**Consultation Response from KC,
Lead Local Flood Authority**

2025/91370 Land at, Gynn Lane, Honley, Holmfirth, HD9 6LF

**Demolition of existing dwelling and erection of 50 dwellings with associated access,
infrastructure and associated works**

Date Responded: 28th July 2025

Detail
FLOOD ROUTING PLAN

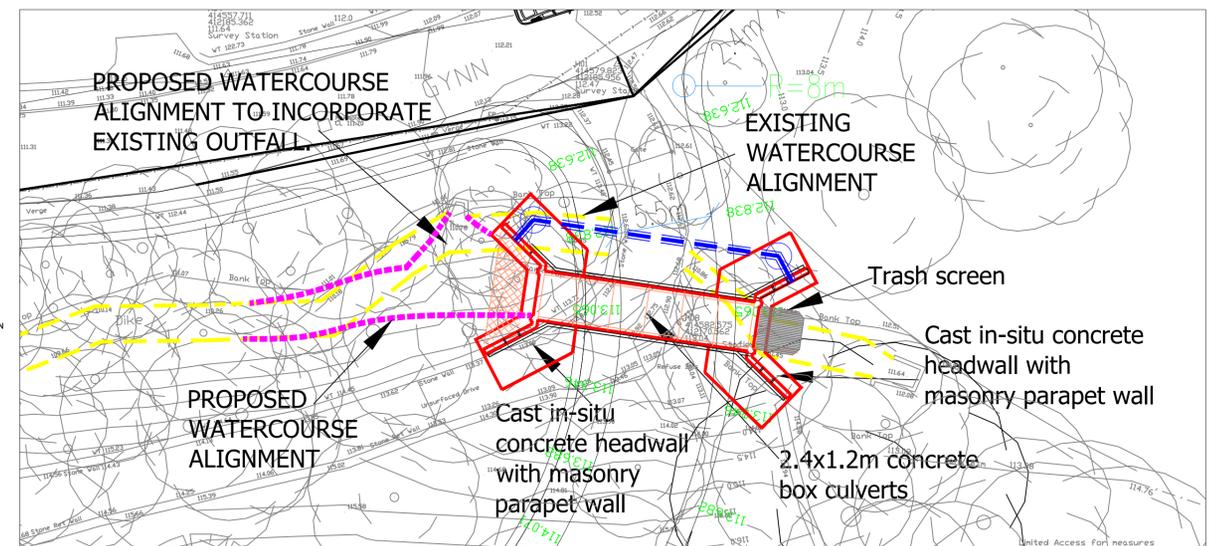
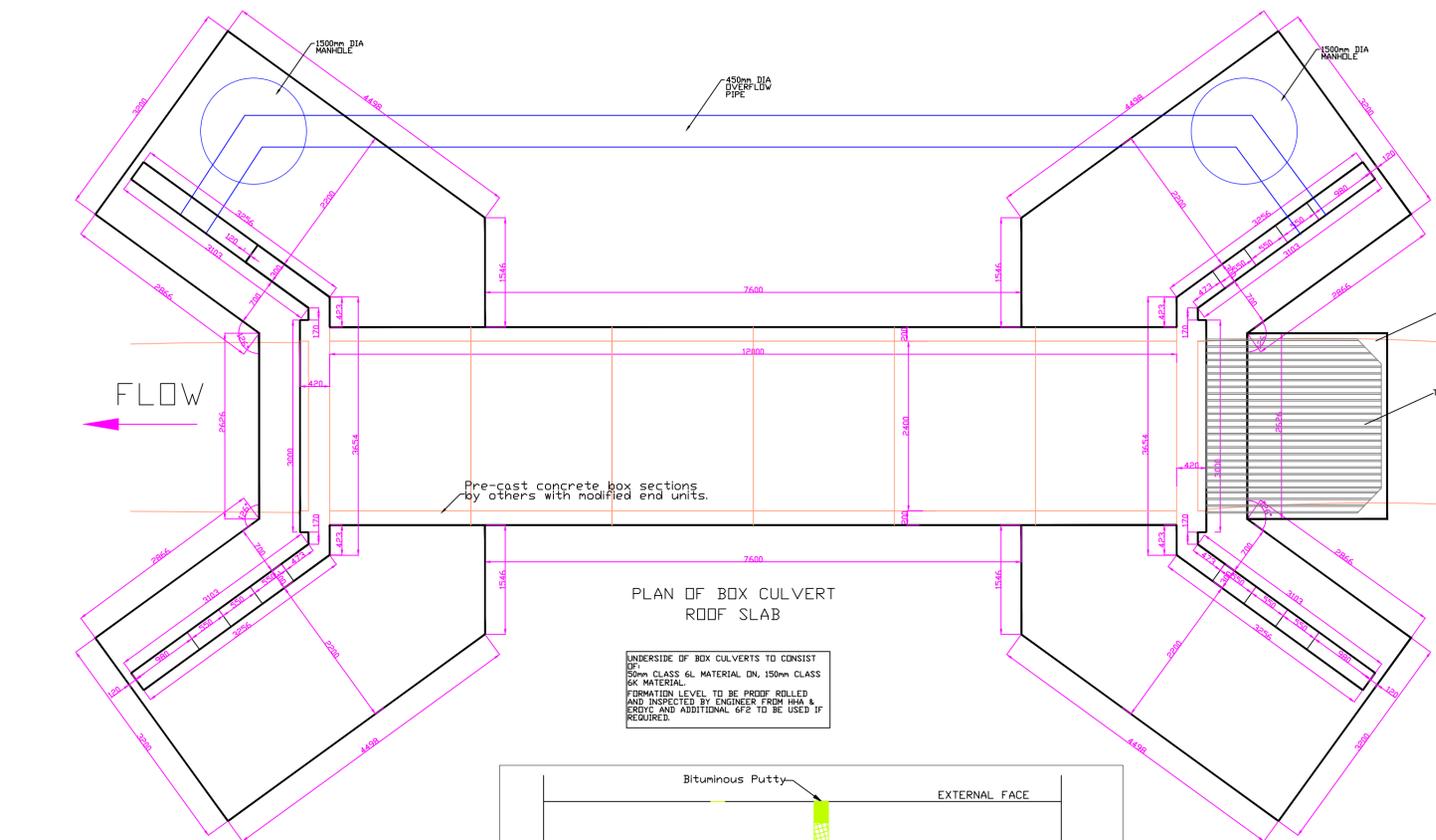
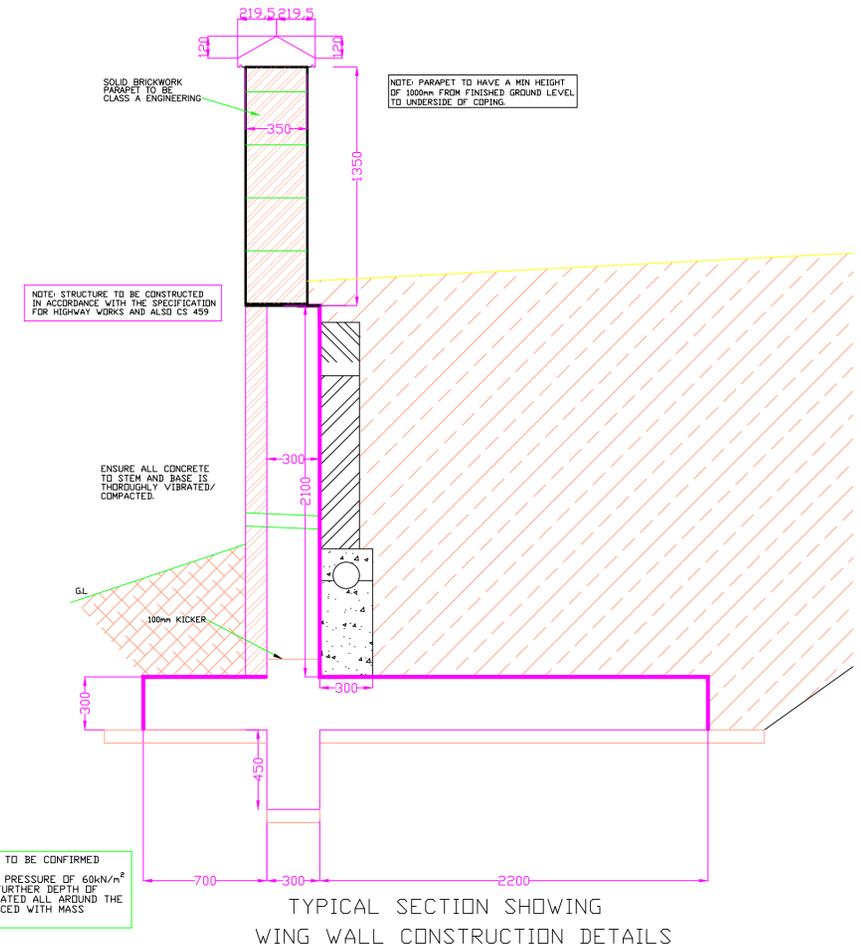
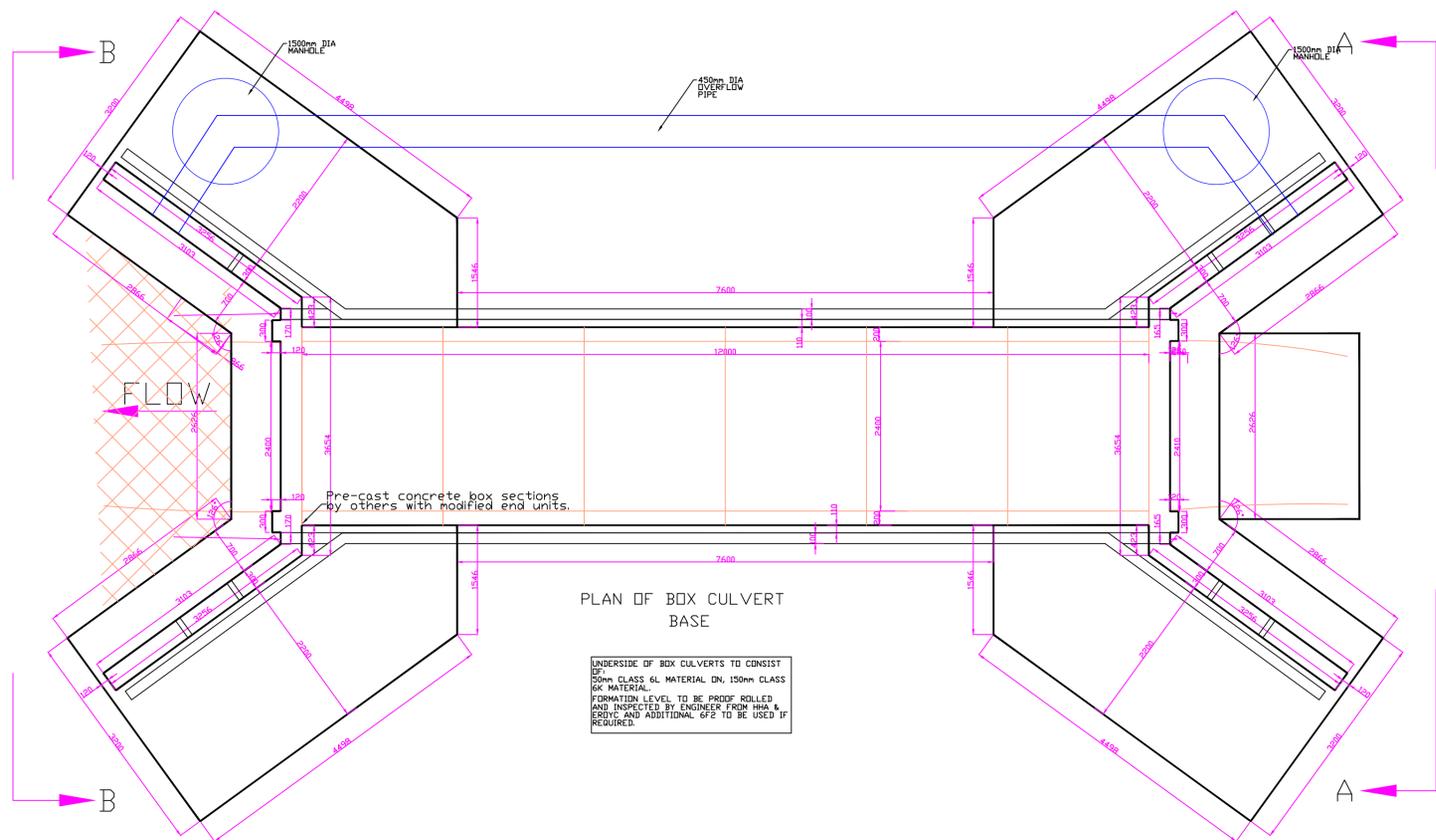
There are no concerns for catchment surface water flood risk. The design for the site's flood routing is of course important. As the route would be down the access road, getting water into the watercourse and not down Gynn Lane has to be adequately considered.

Submitted drawings suggest that successful flood routing has been considered. However, the access road and getting blockage scenarios and exceedance events back into the watercourse needs to be considered.

An examination of low spots and retaining walls for plots 32/33 could be problematic unless the turning area is isolated from adjacent overland flows.
